Diane Sarkies - NWRL EIS 2 Submission of Comments Application No SSI-5414

North West Rail Link
Environmental Impact Statement 2
Submission of Comments for Consideration

Application No SSI-5414

Figure 6.12 Cherrybrook Station - Indicative vehicle and pedestrian movements

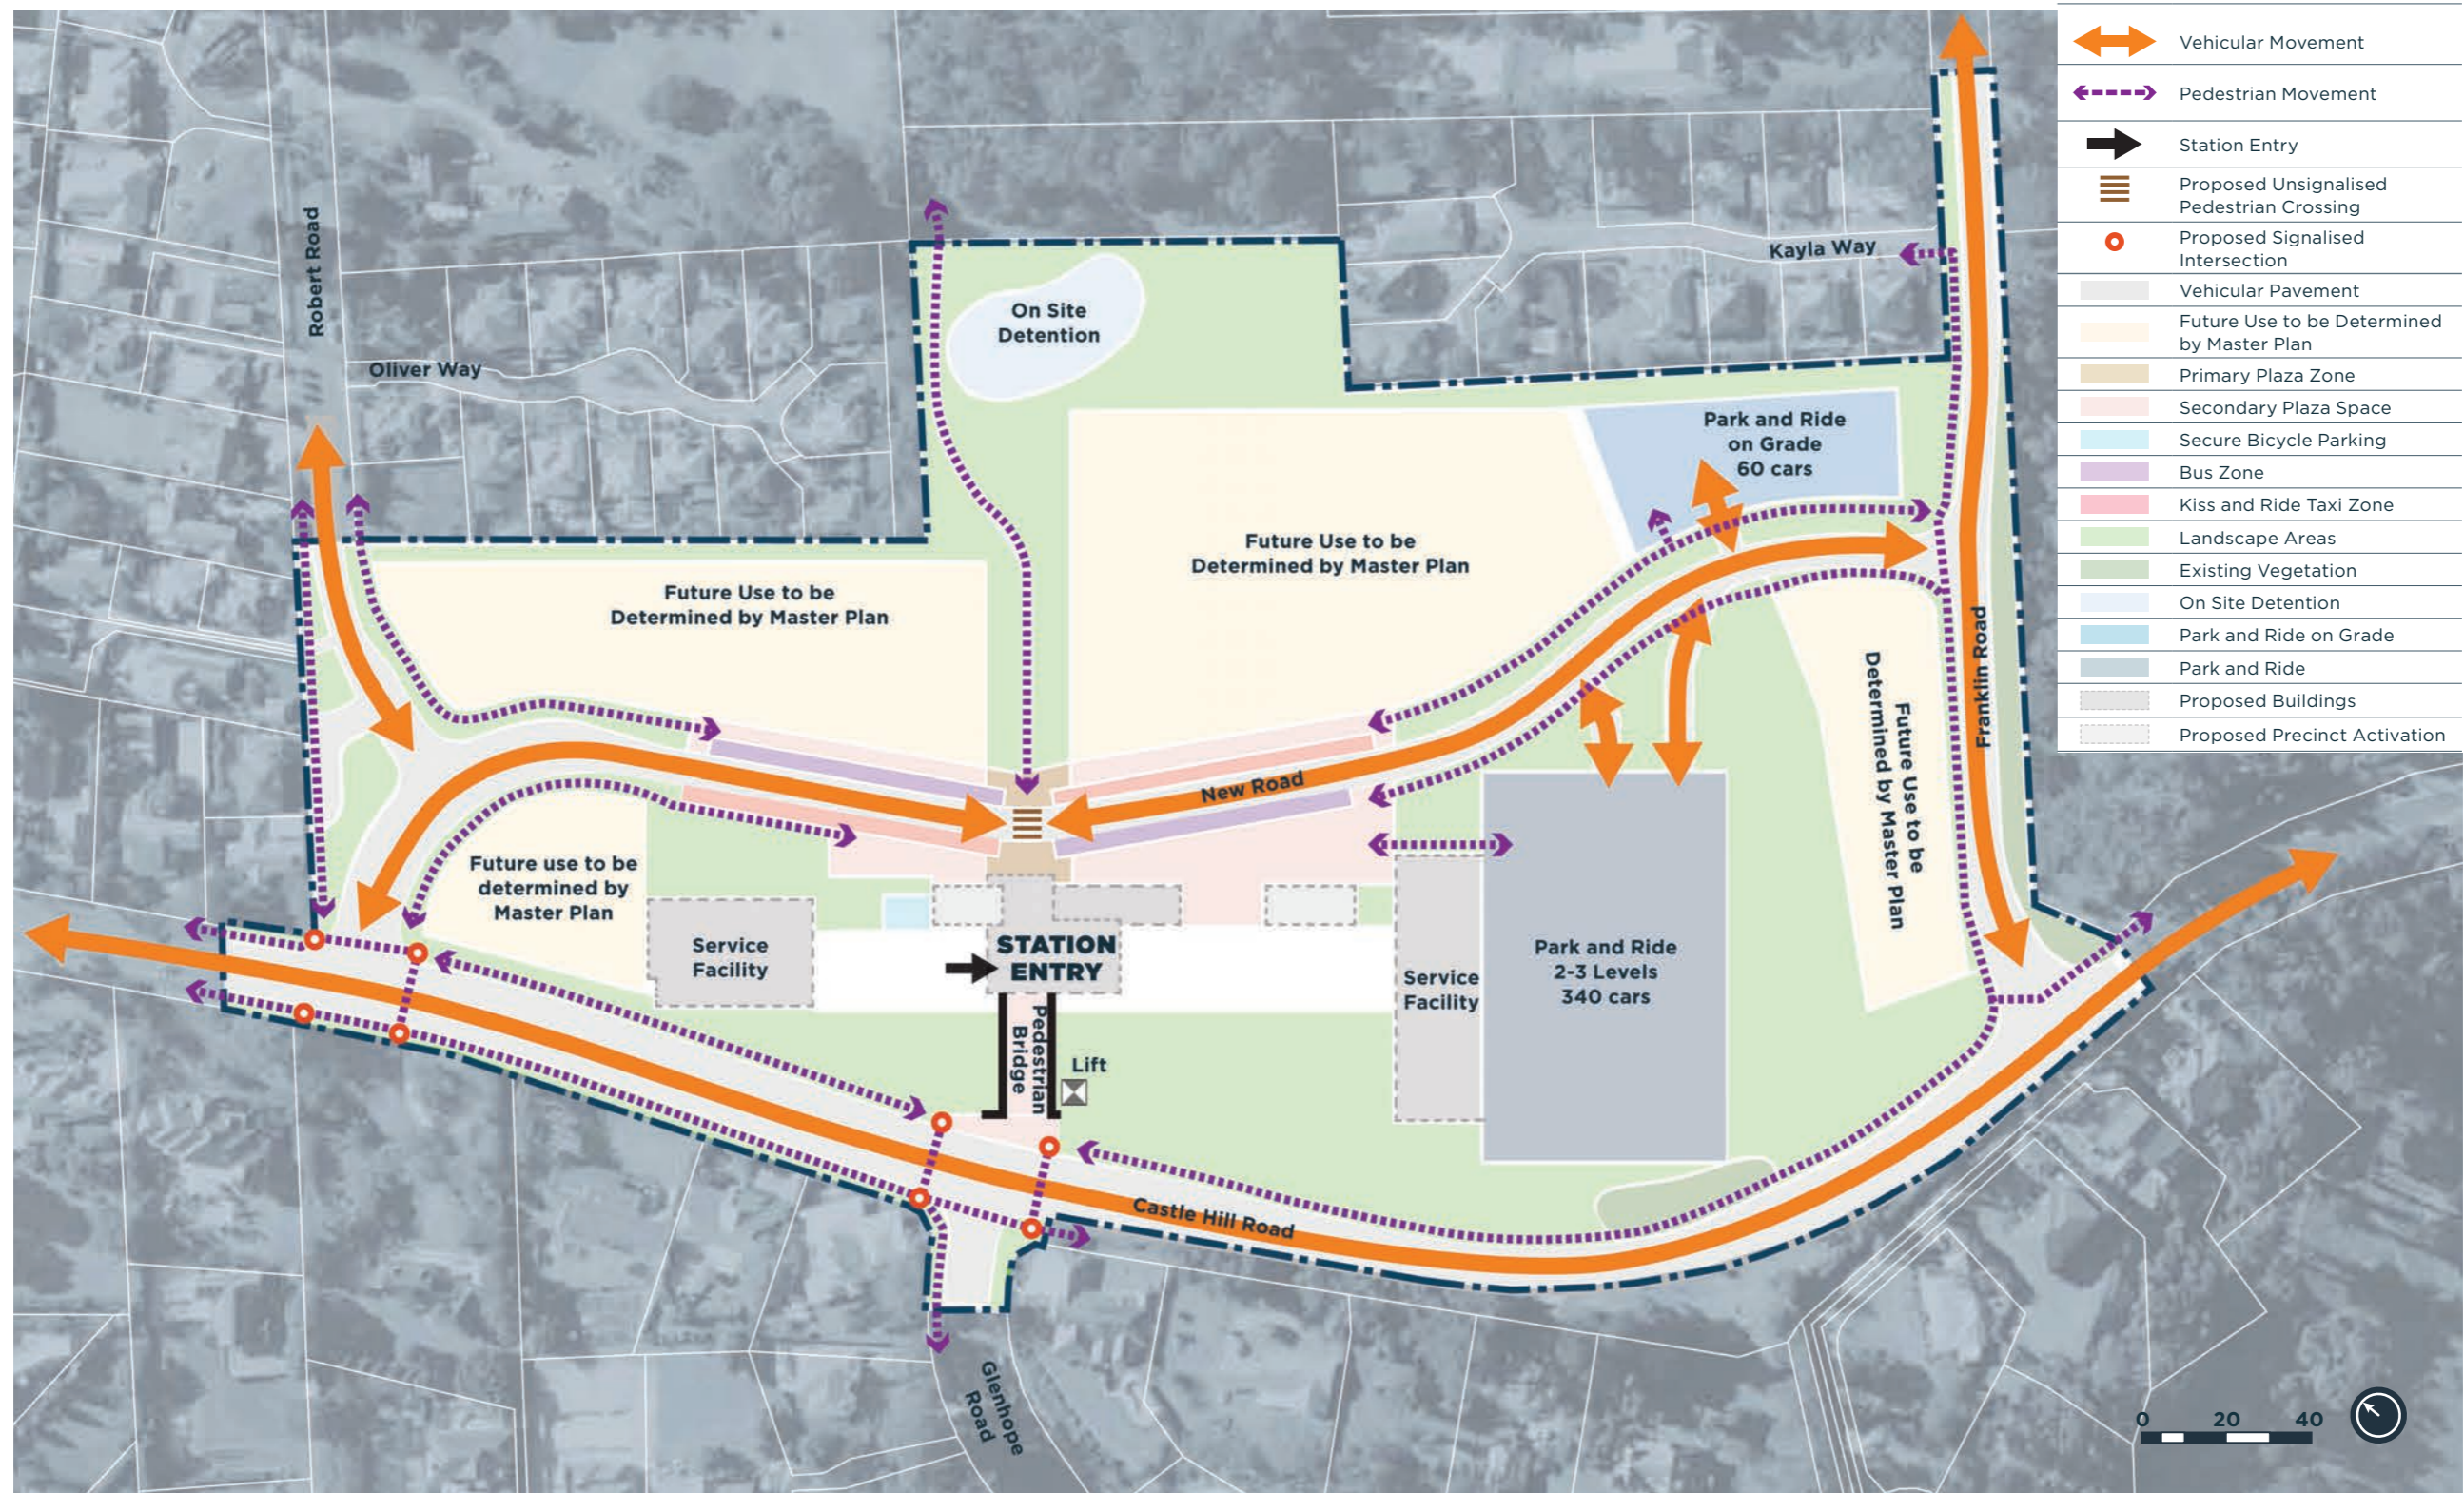
I object to the conversion of Robert Road from a quite, narrow local domestic street to a major bus route devoid of on-street parking for visitors and commercial vehicles.

2. Busses in Robert Road would add approximately 10% more vehicle movements per day.
3. No standing or parking in Robert Road deprives 109 dwellings of on-street parking for visitors and commercial vehicles in Robert Road. Alternative parking in Dalkeith Road and its adjoining streets is restricted owing to the current configuration of private roads and cul-de-sacs

4. The safety of children and other users of Robert Park would be compromised by fast moving busses and cars that may be encouraged to speed as a result of no parked cars in Robert Road and the removal of the "chicane" in the vicinity of the park. The current parking of cars on both sides of Robert Road promotes a traffic calming effect and the road becomes a "thank you" street.

5. Robert Road is a narrow street approximately 8m wide. To allow the passage of two passing busses it would be necessary to severely prune the trees that exist on both sides of the road reducing the current attractive streetscape to an ugly corridor of tree stumps. Also the steep climb out of John Road would create significant noise levels and diesel exhaust pollution
6. Robert Road in its current state would be a convenient cycle route for local train customers
7. The collection of up to 236 garbage, garden waste or recycling bins on Robert Road collected 7AM to midday on Tuesdays would result in lengthy delays to busses approaching Cherrybrook Station and pose a significant risk of collision whilst overtaking stationary or slow moving garbage trucks

- 1 LEAVE ROBERT ROAD ALONE. Traffic lights channeling traffic in the vicinity of the Robert Road/ Castle Hill Road to be as proposed provided that the changes are predominantly within the proposed NWRL Cherrybrook Station Site. Left in construction access to Cherrybrook Station not be allowed under any circumstance (as previously advised in information sessions associated with EIS 1)

- 4 Re-route 632, 642 and 642X busses both to and from the City, along County Drive and Castle Hill Road. Entry and egress to Cherrybrook Station via the traffic light controlled intersection at Robert Road
